From: Jack Dowling [REDACTED]
Sent: 21 April 2020 14:20
To: Daun Johnson <Daun.Johnson@arun.gov.uk>
Subject: RE: Request for further information BR/55/20/PL

Existing East Elevation

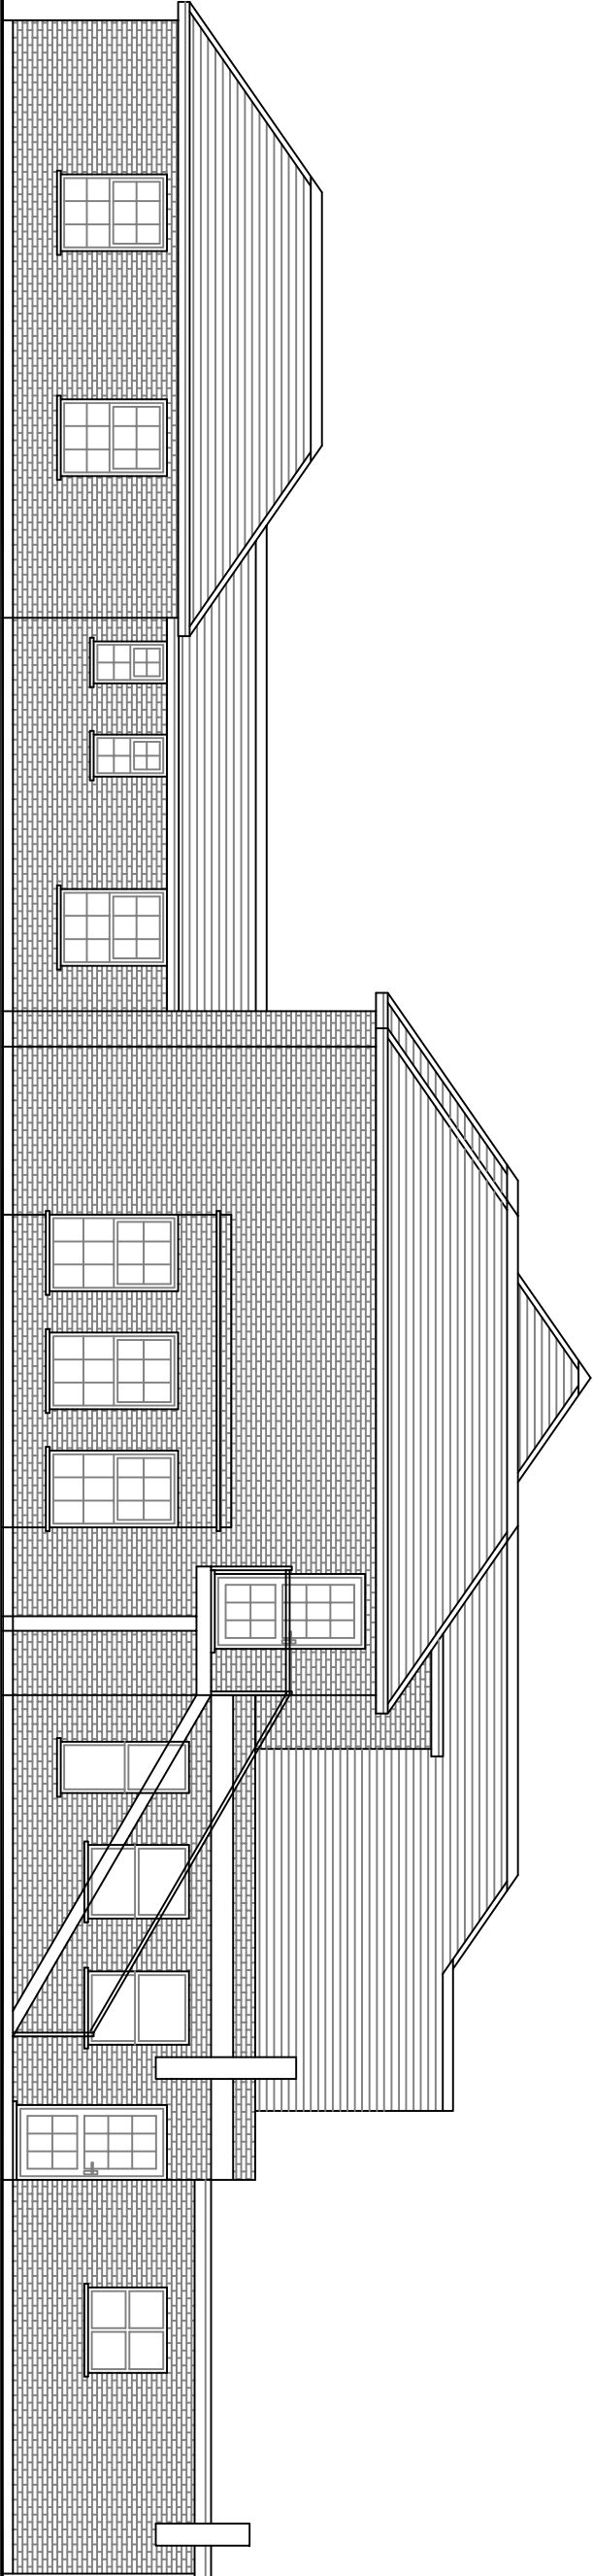
- The existing ground floor plan and north elevation do not accord. Please show the staircase on the floor plan.
- The existing ground floor plan and east elevation do not accord. Please show the staircase on the floor plan.
- The existing first floor plan and north elevation do not accord as there is a window missing.
- The proposed ground floor plan and east elevation do not accord. Please show the staircase on the floor plan.
- The proposed first floor plan and north elevation do not accord as there is a window missing.
- We still await the fee.
